Our Ref: A/110/18/HH
Your Ref:

Town & Country Planning Act 1990 (as amended)
Town & country Planning (Development Management Procedure) (England) Order 2015
Application for Planning Permission for Works or Extension to a Dwelling

Development First floor extension over existing garage to provide accommodation for the sole use of the existing dwelling. Resubmission of previously approved planning application A/16/11 (APP/C3810/D/11/2154095)

Location Four Elms Ham Manor Way Angmering

EXISTING NORTH-WEST ELEVATION

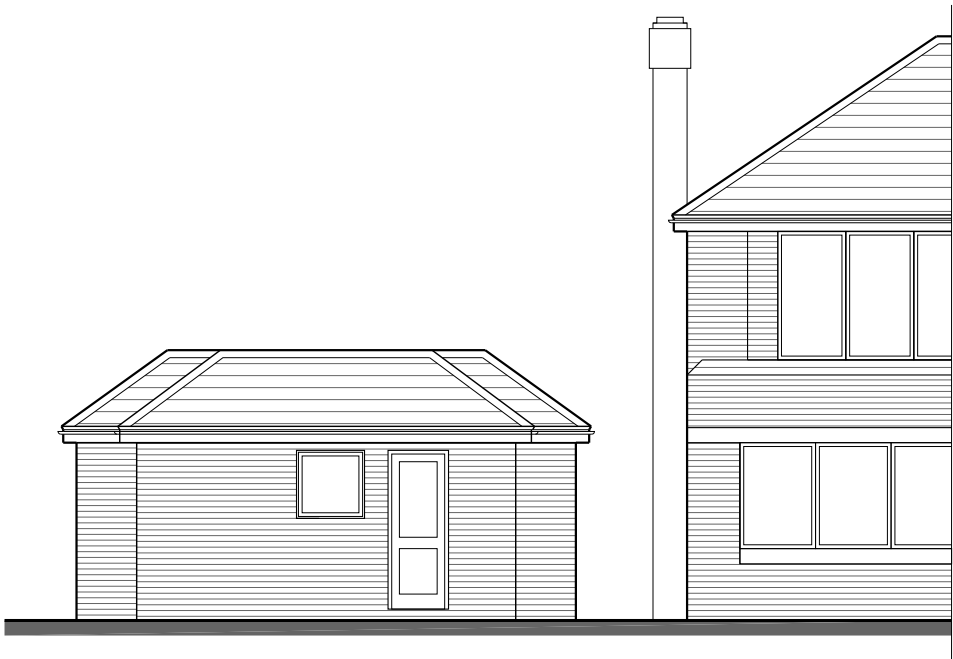
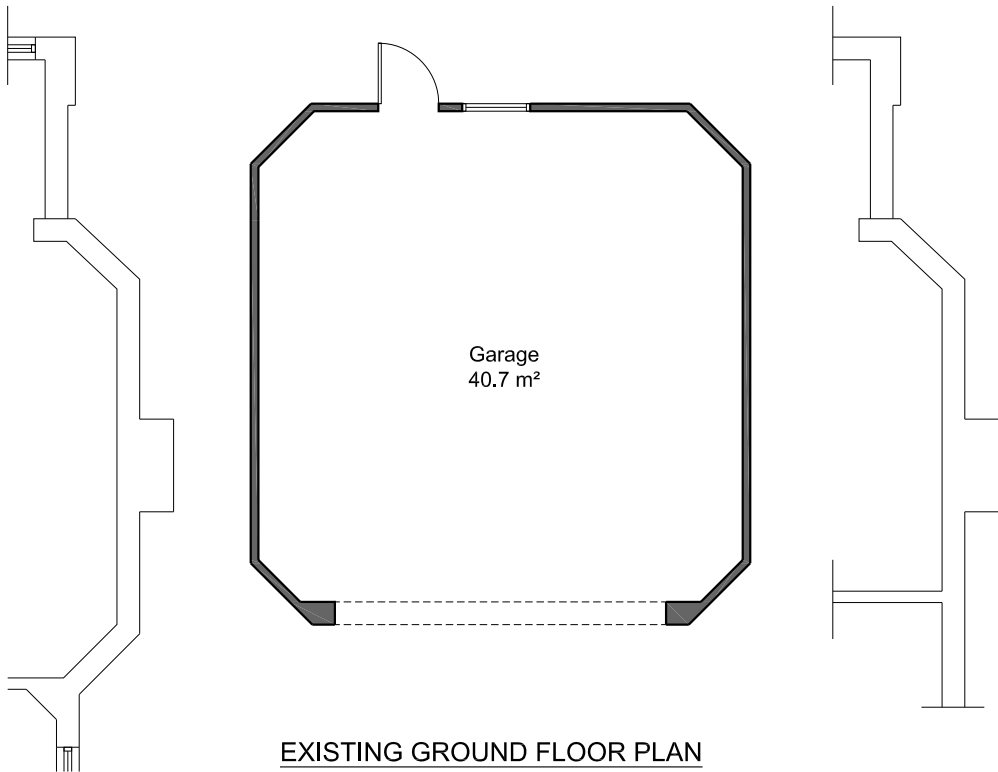
Please amend either the existing ground floor plan of elevation, as a small door has been omitted from the elevation but indicated on the floor plan.

LOCATION PLAN, Sc. 1:1250

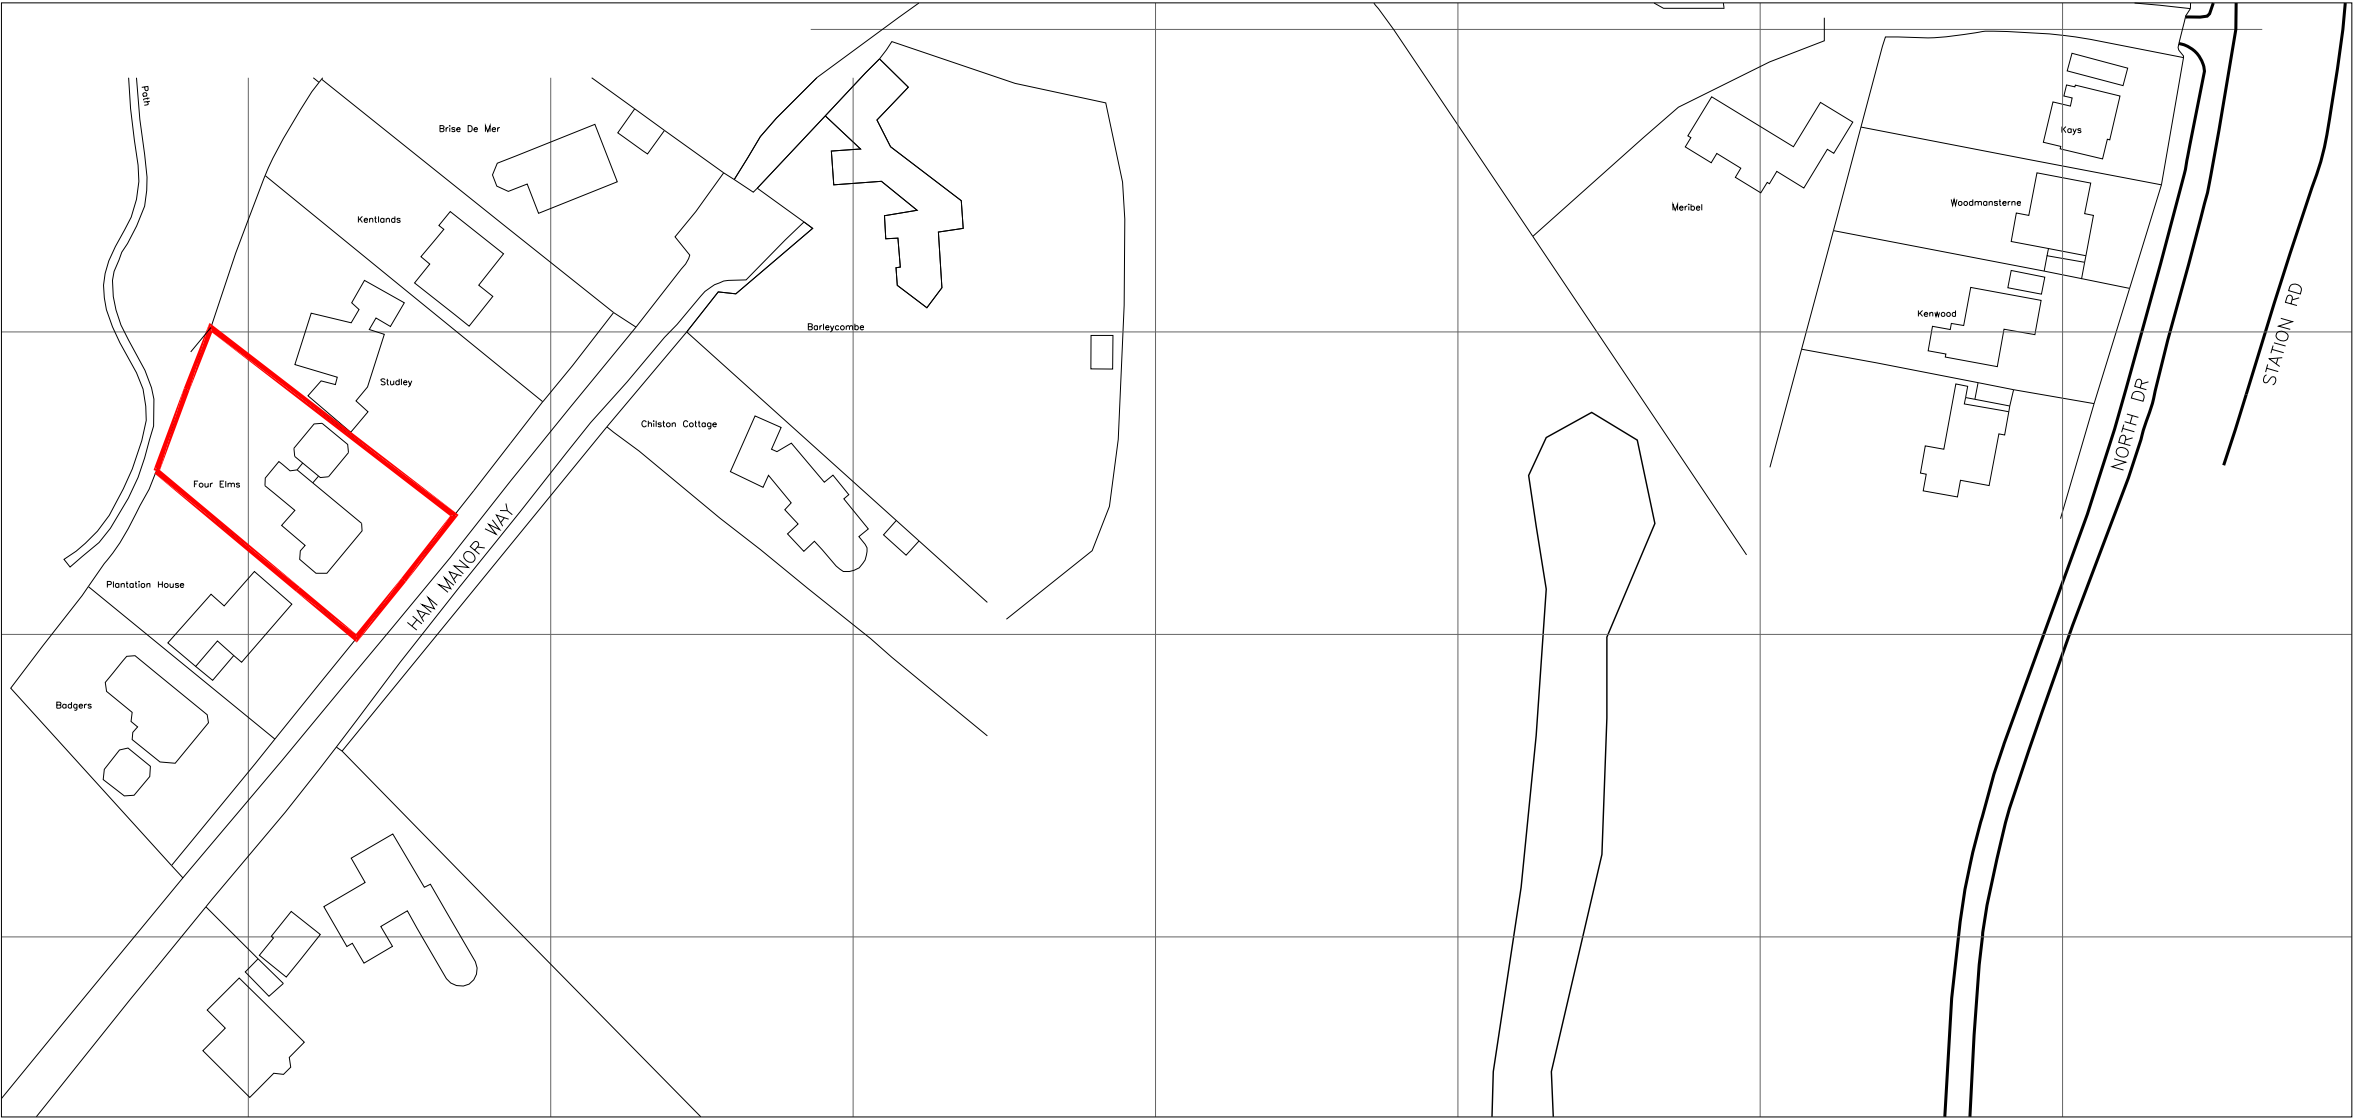
Location Plan - revised

Please submit 1 electronic or 3 paper copies of a revised location plan at a scale of 1:1250 or 1:2500 for rural areas to include 2 named roads. Further details of what must be included on the plan can be found in the National Validation Requirements.

SITE PLAN, Sc. 1:500

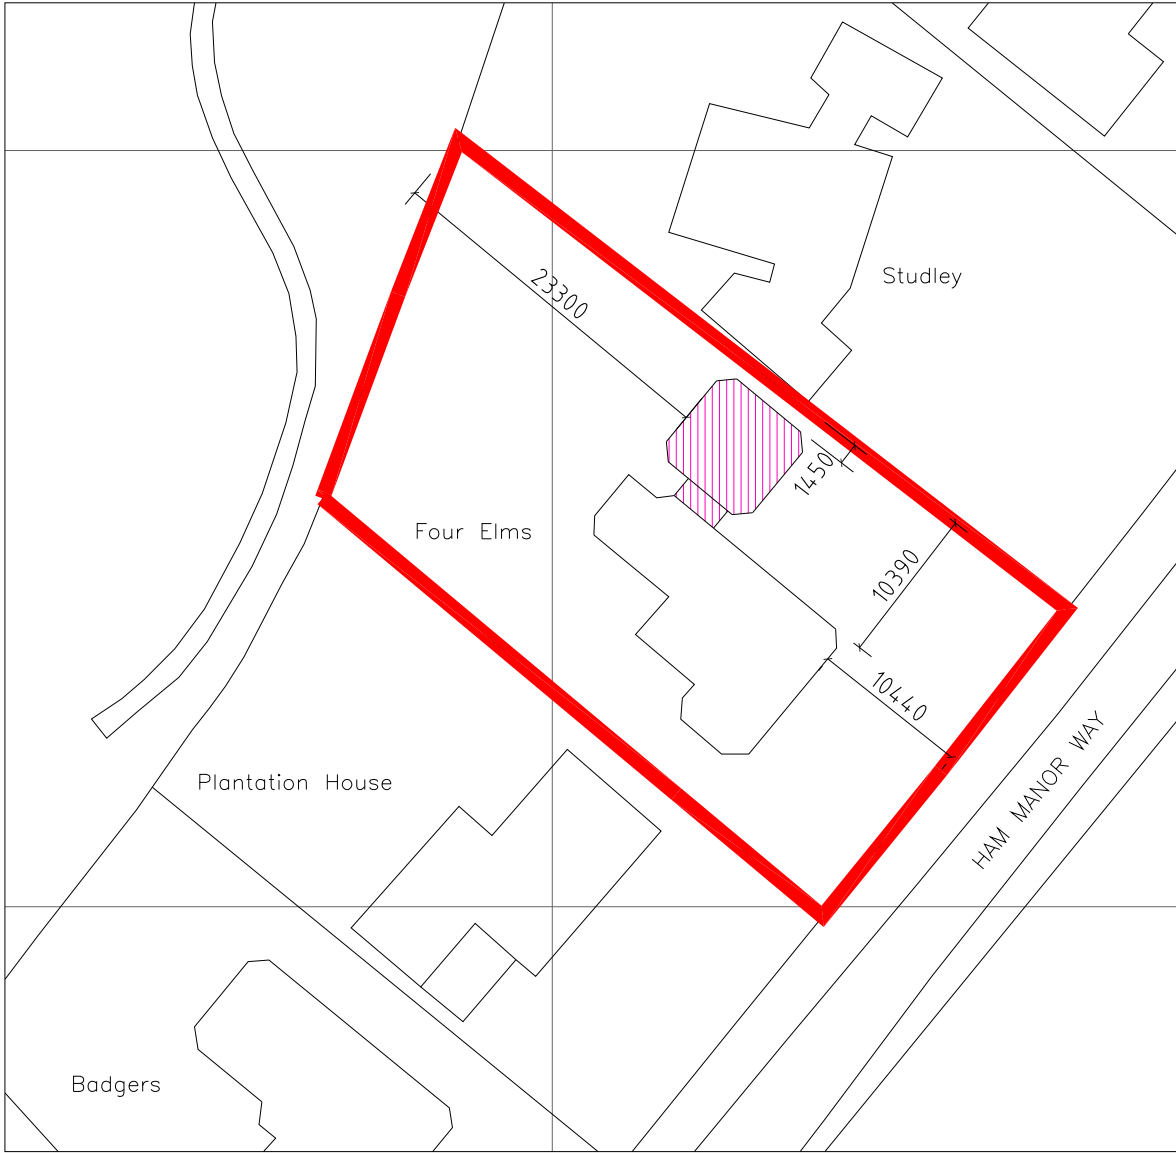
Block Plan - revised

Please submit 1 electronic or 3 paper copies of a revised block/site plan at a scale of 1:500 or 1:200 to include 1 named road. Further details of what must be included on the plan can be found in the National Validation Requirements.
